Development Facilitation Team (DFT) – Review Comments

Project No: PR-2023-008085

Application Number: SI-2023-01465

Project Name: Spanish Walk Subdivision – 410 Camino Espanol

FRONT ELEVATION
SCALE = 1/4" = 1'-0"

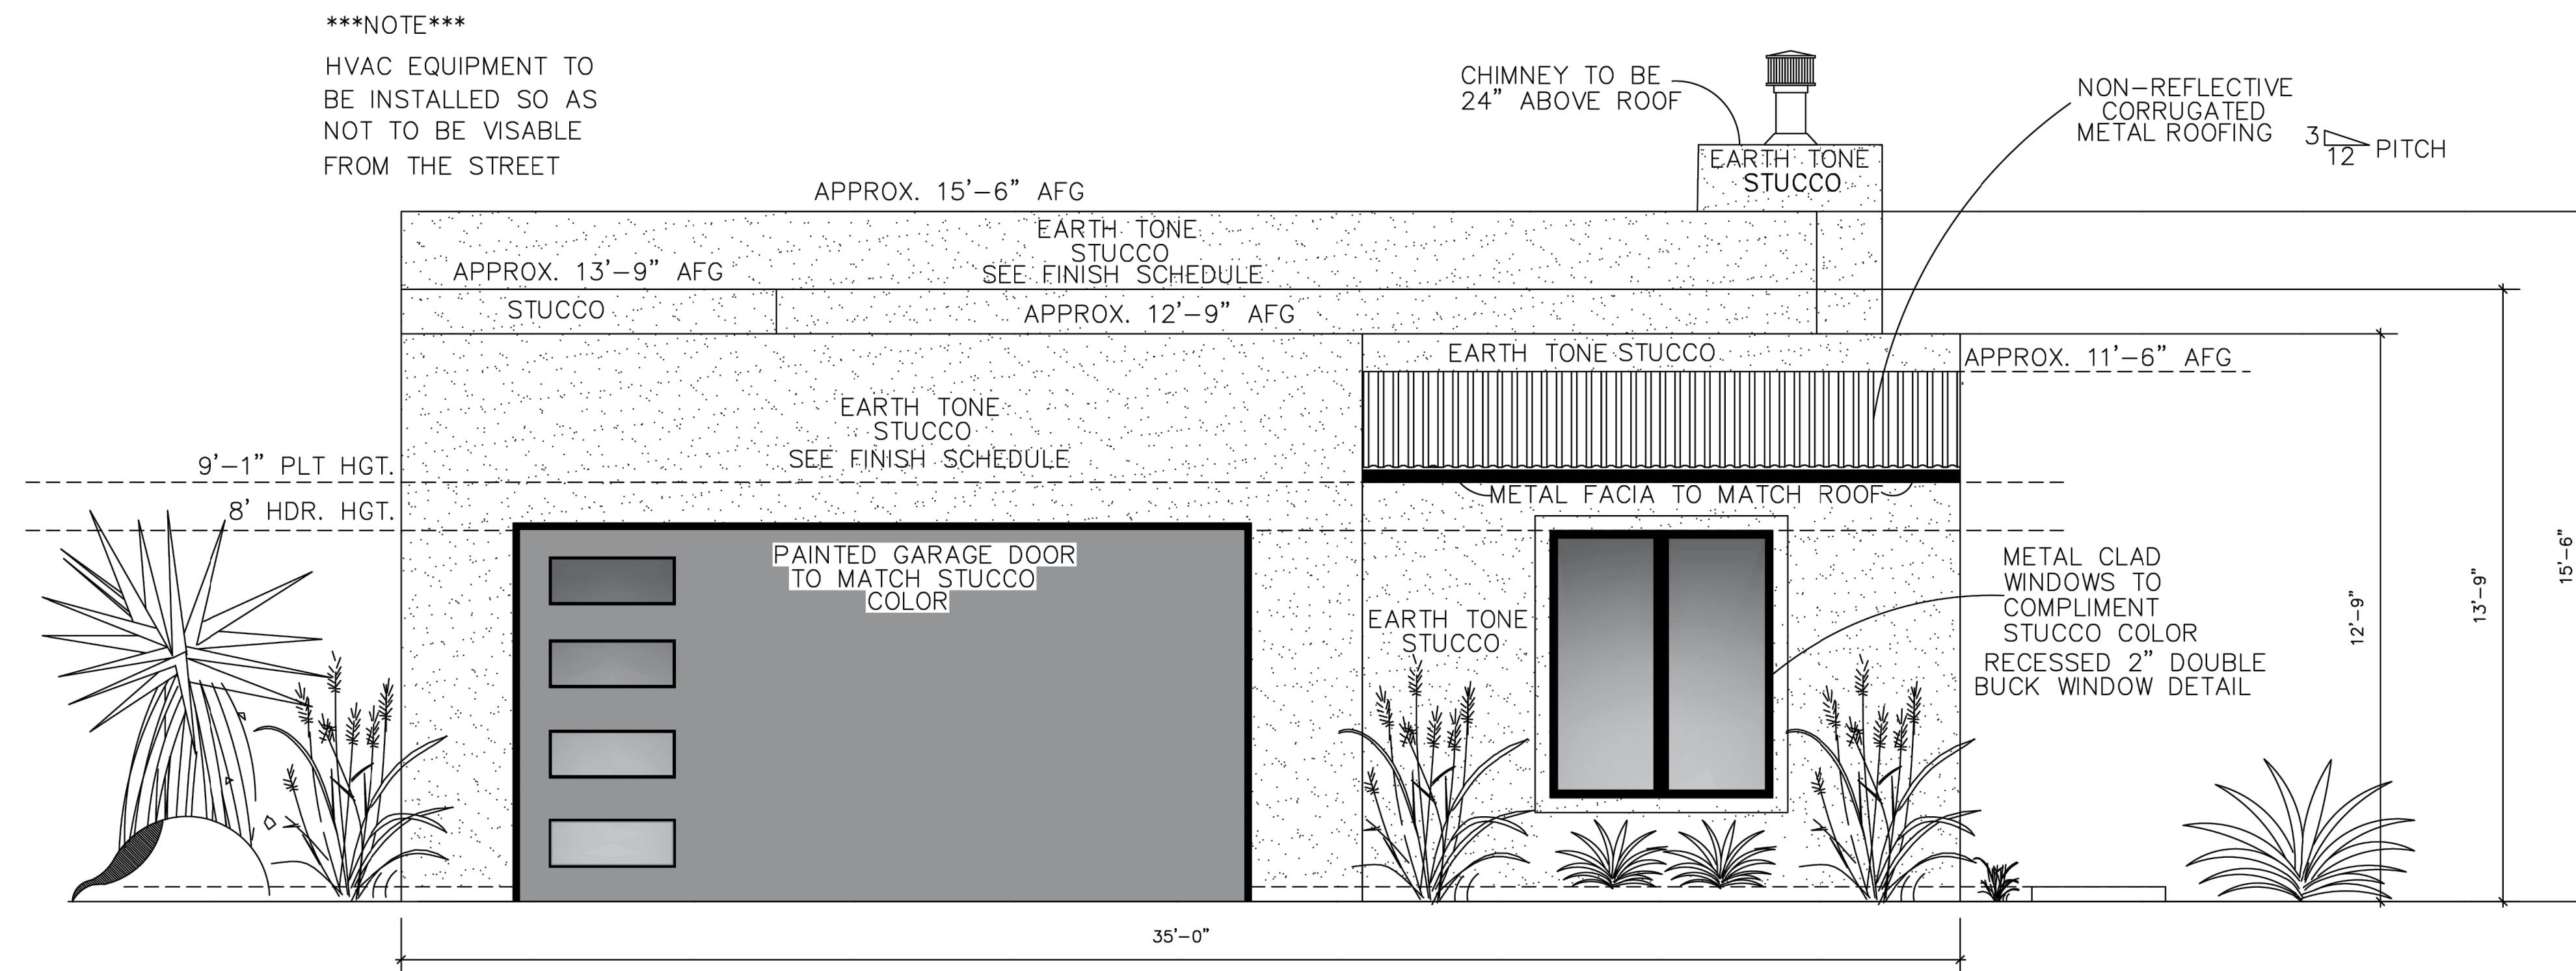
9. Elevations:
- A. Elevation sheet shall have a title block.
Please fill in the title block with proper sheet title and address on the Elevation sheet. The elevation sheet has been updated. See attached.

- B. Elevations shall include a schedule (List of colors and materials).
Proper schedule has been added to the Elevation sheet.
- C. General Notes: building design standards (pursuant to 5-11(C) Low-density residential development, etc. shall be provided.
Relevant notes have been added to the Elevation sheet.

- D. All dimensions shall be provided.
Dimensions have been provided on the Elevation sheet.
